Greatford Parish Council Written Representation to Planning Inspectorate with regards to the proposed Mallard Pass Solar Farm.

This written representation covers in more detail the issues raised during the open floor hearing of 17/05/2023.

The primary concern of Greatford Parish Council is the potential effect this proposed development could have upon increasing the flood risks from the West Glen river that runs through Greatford, other significant concerns include the loss of BMV agricultural land, traffic implications and the degrading of local amenity space, these issues are covered in detail in the following written representation.

Plate 7: Typical PV Array

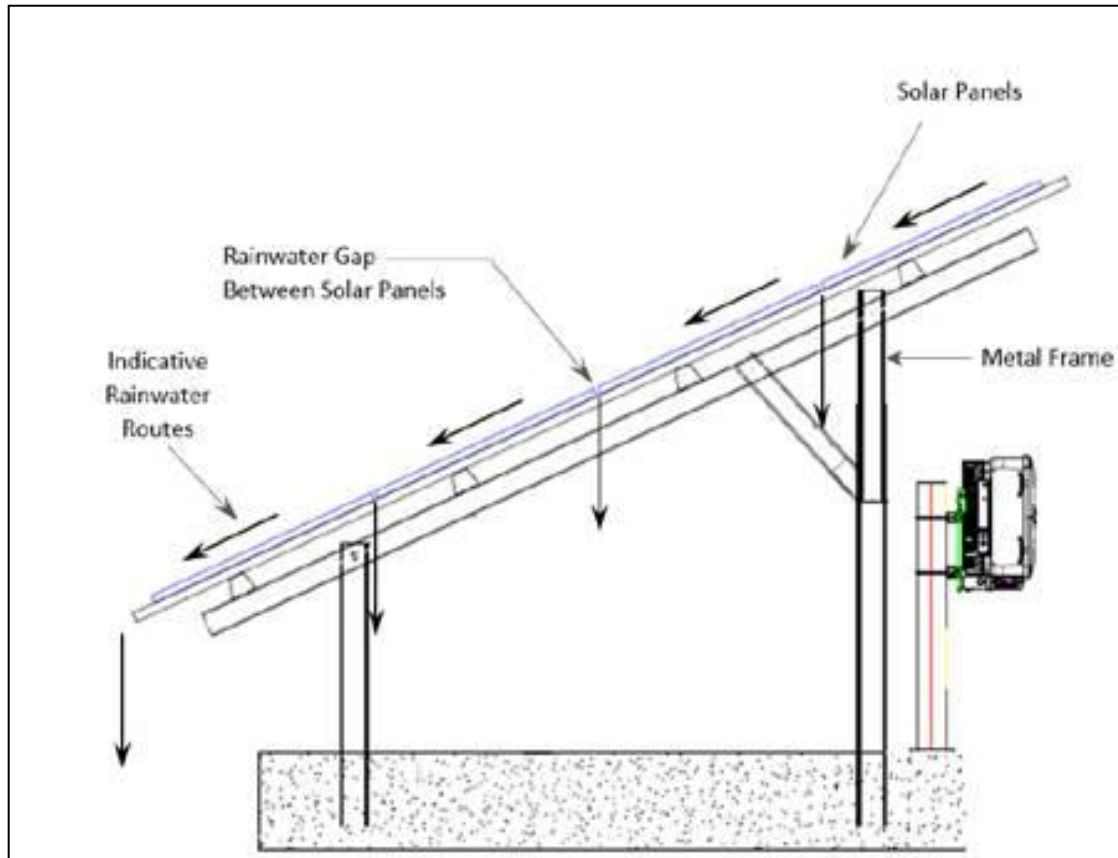
The next paragraph of the outline surface water drainage strategy states that “the raised nature of the PV arrays will not prevent the soil from absorbing rainwater as the panels will not be placed on the ground and each PV row will be separated, with the same area of soil available for infiltration as per the baseline scenario.

This in our opinion is incorrect. The water running off the driplines of the solar panels will fall vertically under gravity onto a small area of soil immediately below the drip lines. A small proportion of the water may disperse locally from the area under the drip line through rain splash or be deflected by the wind, however the majority of the water will fall under gravity straight down onto the ground, and then either infiltrate into the soil, or runoff.

The outline surface water drainage strategy, file number 000159, page 16 then goes on to suggest that “once rainfall has fallen on a PV array, the water will be able to spread and flow along the ground under the PV arrays evenly into the rain-shadow of the row below so as to mobilise the same percentage of the ground for infiltration as was available prior to the installation of the PV arrays.

This is in our opinion incorrect. Water will move downwards under gravity and infiltrate into the soil at a rate defined by the (predominately clay) soil type and the level of soil compaction. It may move slightly sideways through capillary action.

If it begins to flow along the ground under the PV arrays as suggested above then it has the potential to cause erosion, rilling, and a loss of soil which will impact the local hydrology and wider ecosystem.

Plate 9: Establishing Grass Mix Under PV Drip Line³¹³²

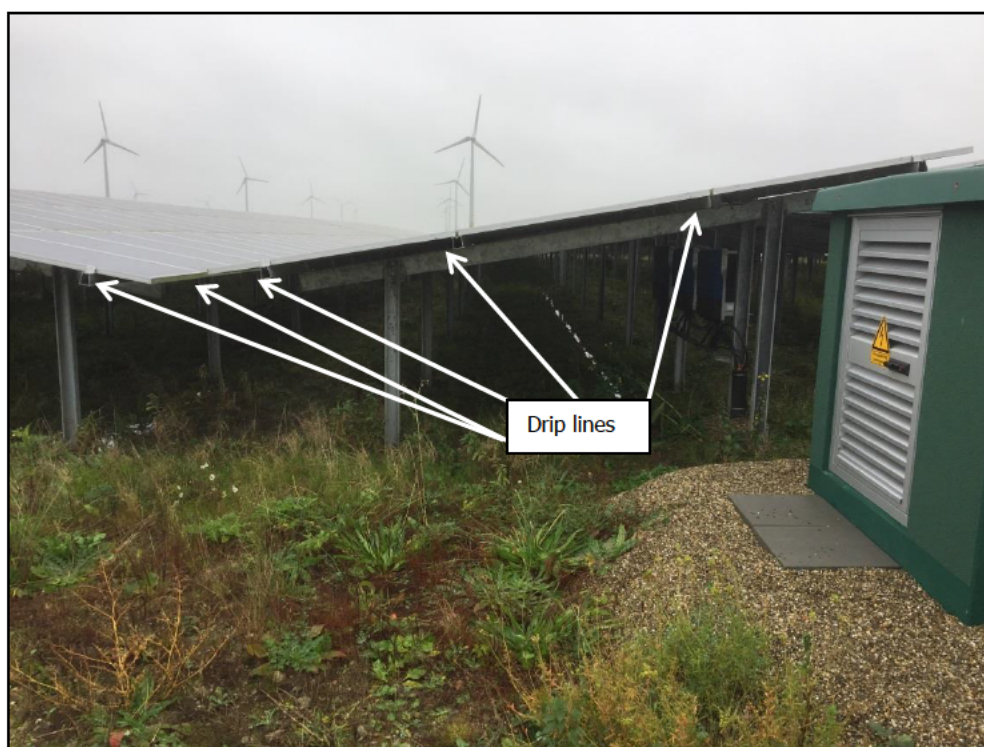
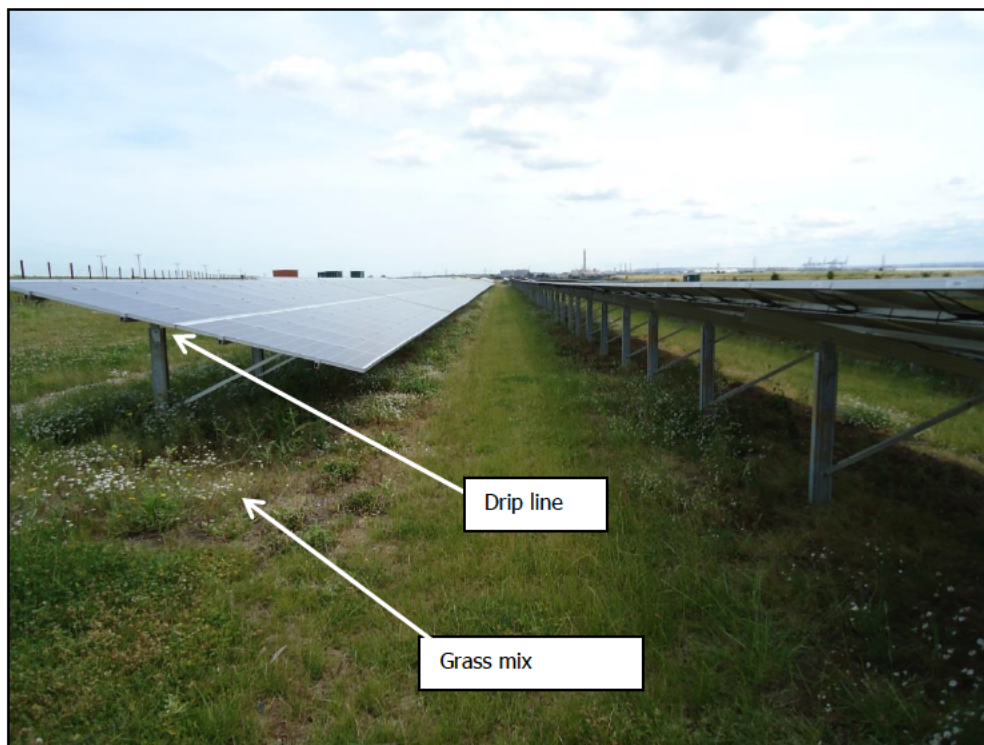
"The key to avoiding increased run-off and soil into watercourses is to maintain soil permeability and vegetative cover. Permeable land surfaces underneath and between panels should be able to absorb rainfall as long as they are not compacted and there is some vegetation to bind the soil surface".

As MP are quoting this in their outline surface water drainage strategy it should absolutely be adhered to in that vegetation should be well established and soils not compacted. To properly establish a hard wearing grass ley will take two years and this needs to be done prior to construction.

The energy of the flow which drains from PV Arrays will be greater than that of the rainfall. Therefore, this could result in erosion under the driplines and possibly lead to ground instability. In addition, intensification of the runoff from panels, along the 'drip line', into small channels / rivulets, could be exacerbated where PV Arrays are not positioned in alignment with topography.

In order to avoid increased erosion rates, the grass beneath the panels would be well maintained throughout the lifetime of the Proposed Development.
